SASES Written Summary of Submissions on Site Selection

[Agenda Item 3]

SASES

15th December 2020

250m buffer added to existing development

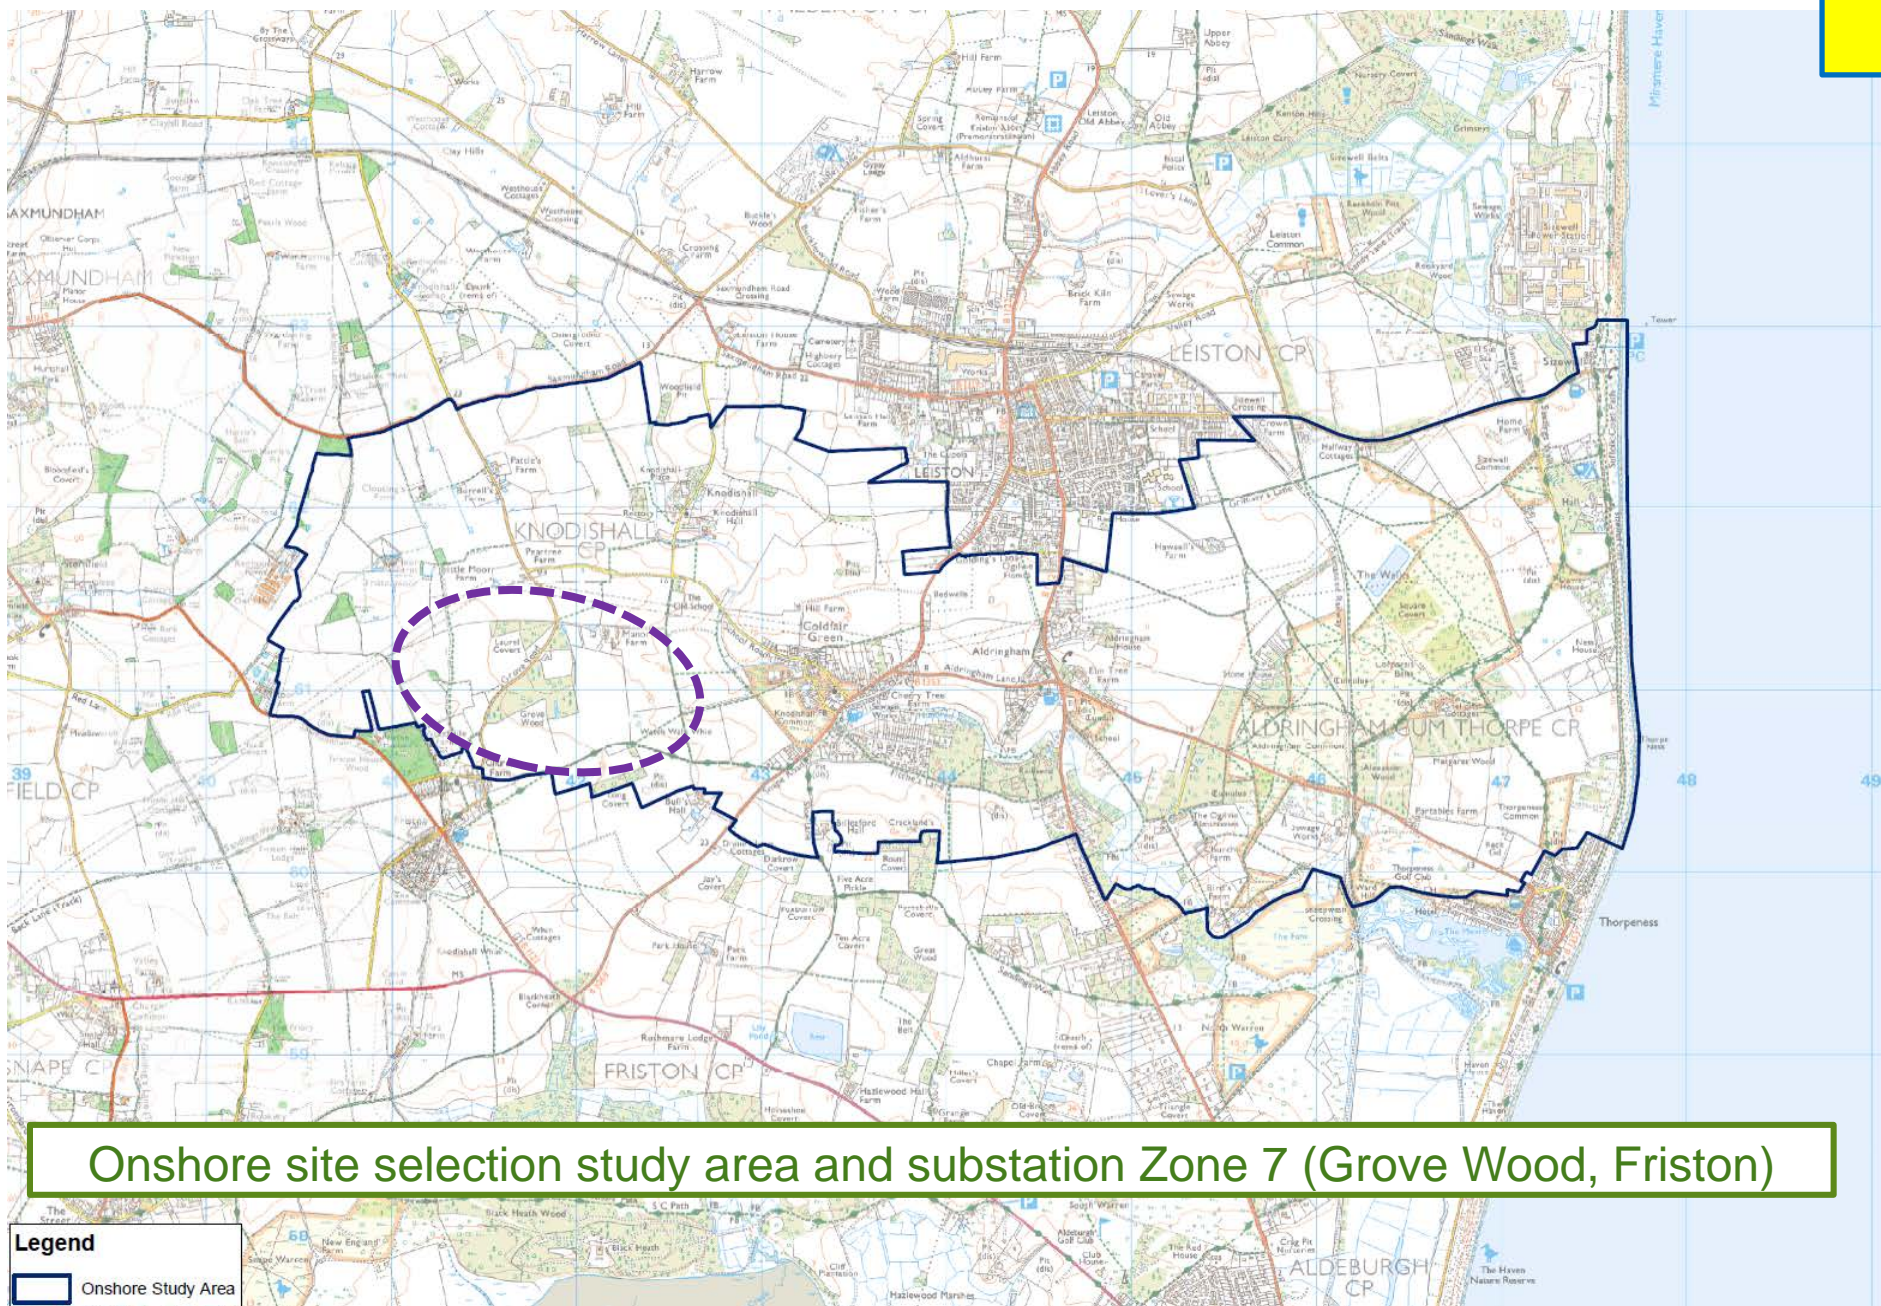
28. SPR's Presentation Slides for Agenda Item 3 (p14) show a 250m buffer zone from existing development was used in the SPR site selection exercise, but it is not apparent why 250m was selected. At Bramford, 600m was the distance used for EA1. If a larger buffer had been used here, it would have eliminated the Friston site.
